Drafted 13 December 2012

**Planning Application, Ribble Valley District
D3-12-1069 Abbey Farm, Nethertown Close, Whalley**

Proposed Site Plan 1:200

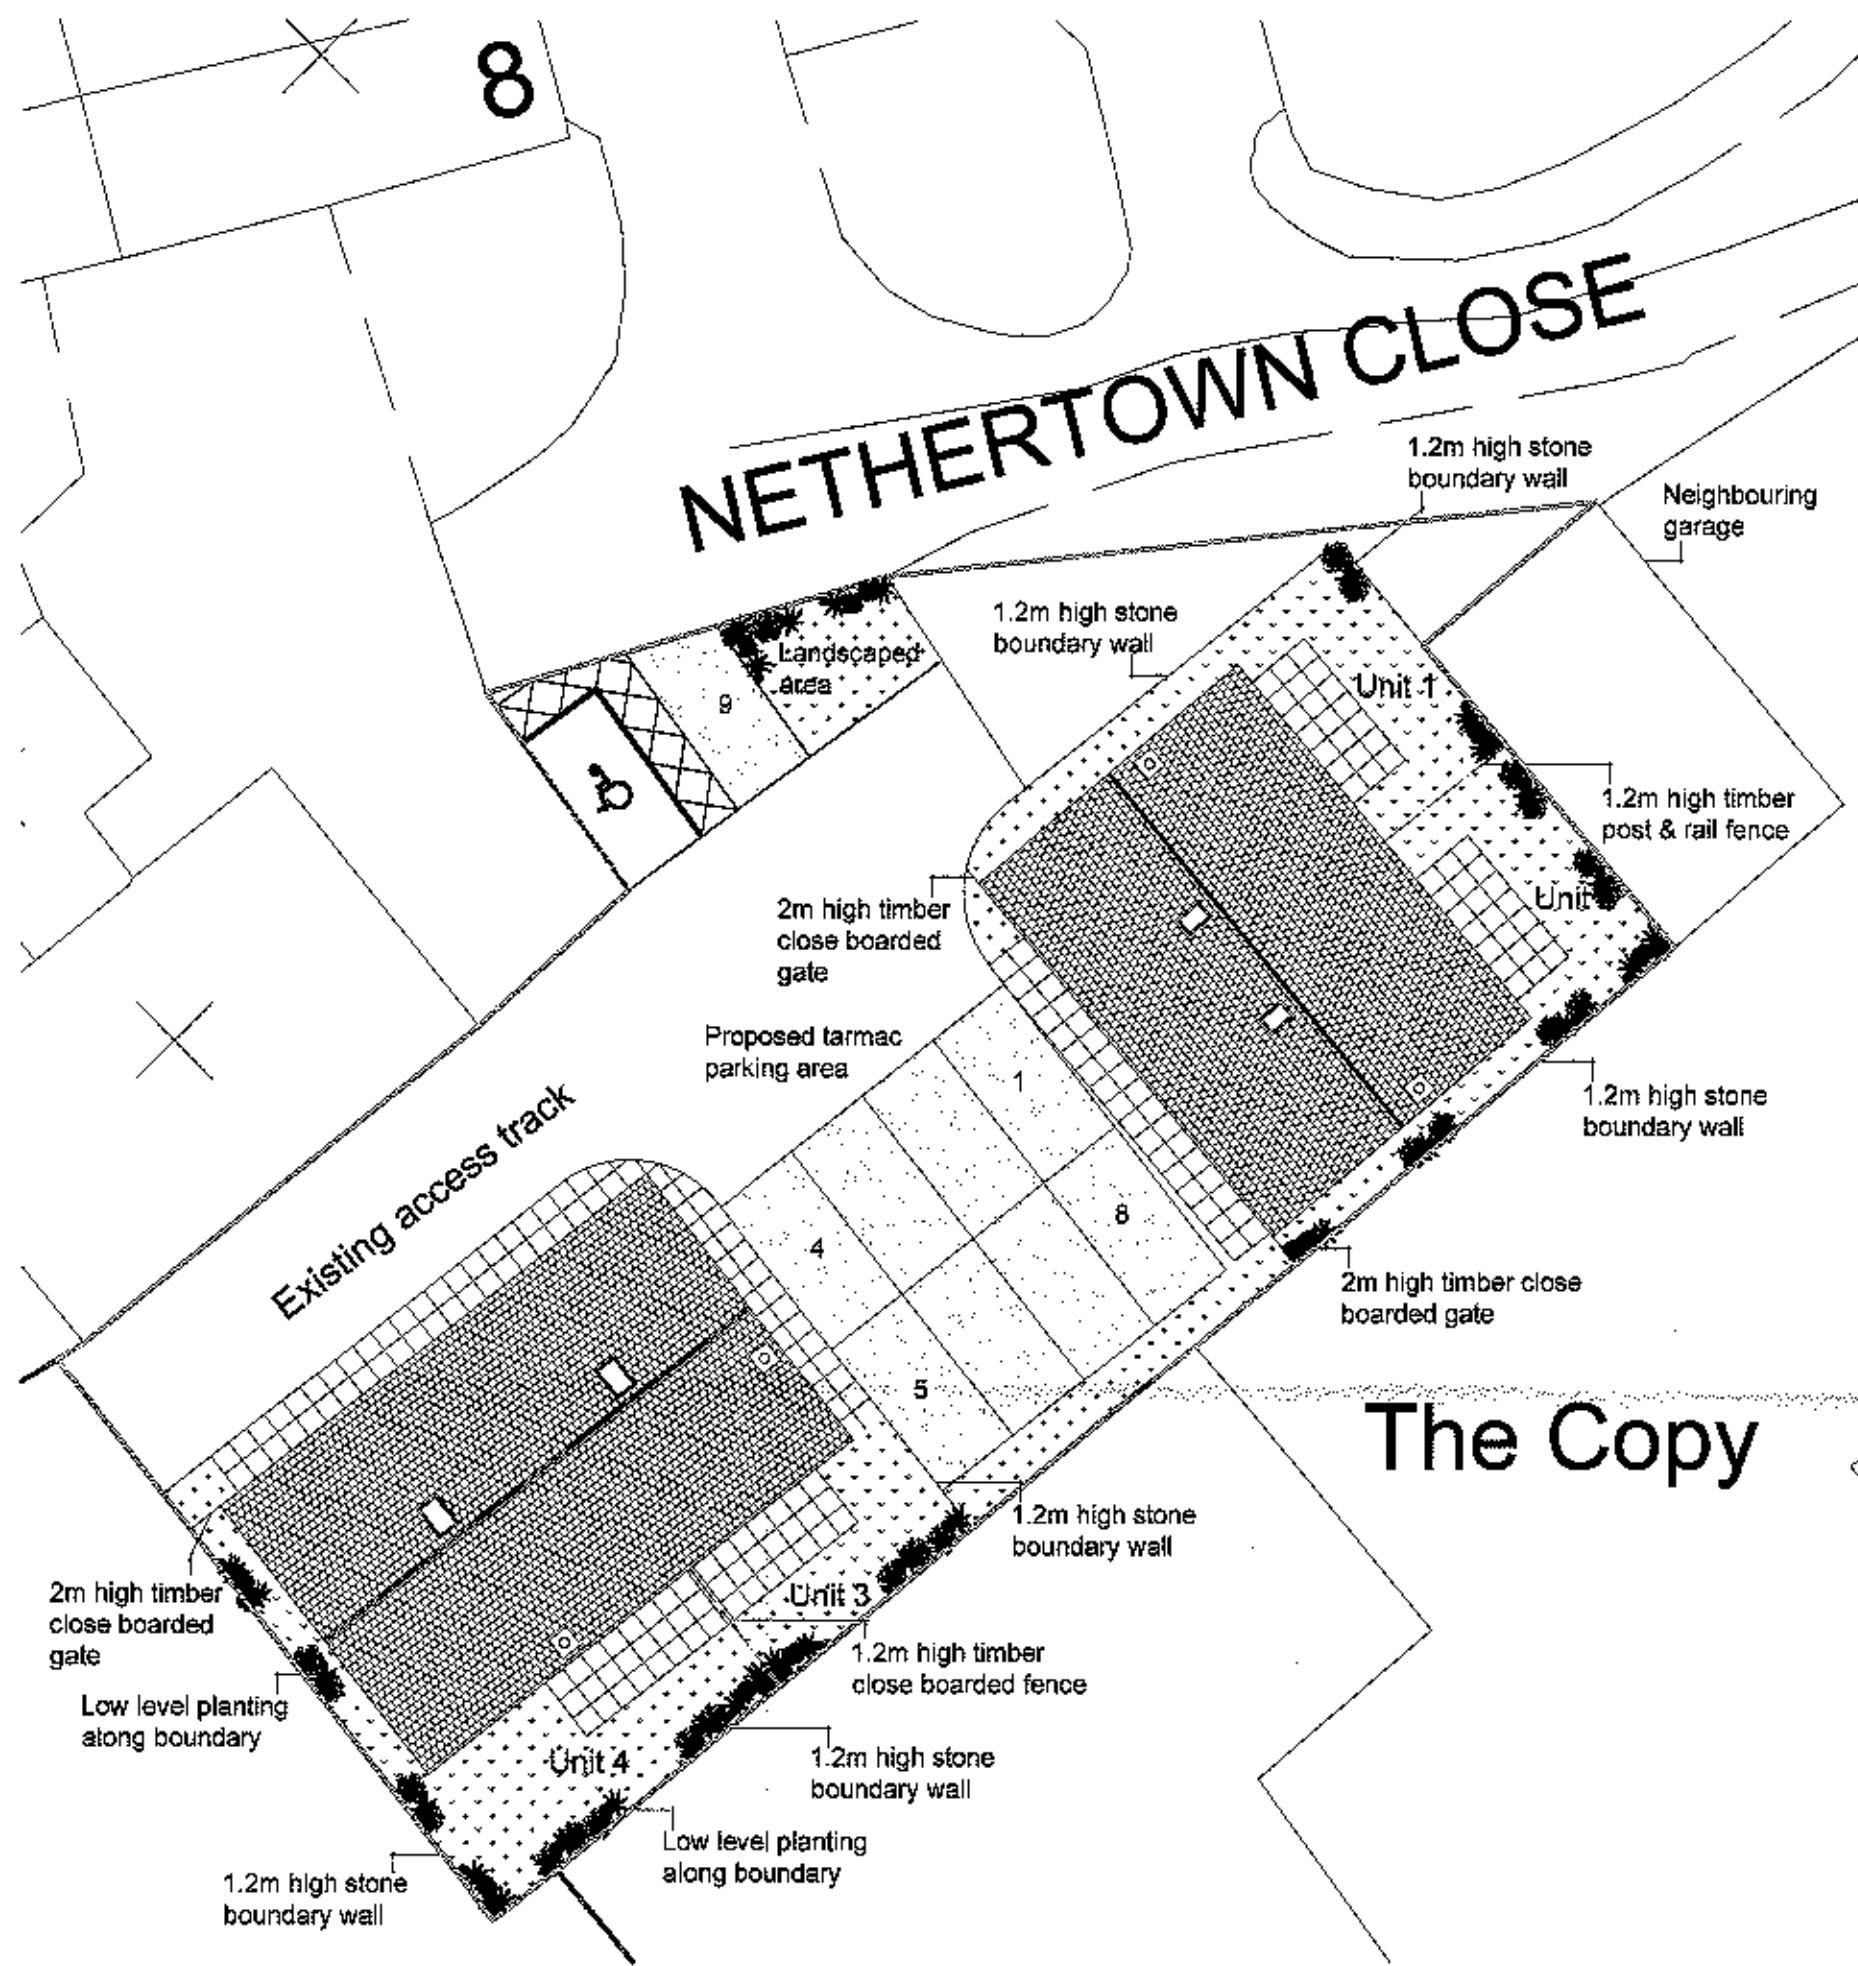
The site plan indicates that there are 9 parking spaces and an additional mobility space being provided. While the mobility space is not adjacent to a specific property, it allows all of the units to be accessible.

In this instance, I have no objection to the tandem parking shown for 1-8, as there is an element of communality with holiday cottages.
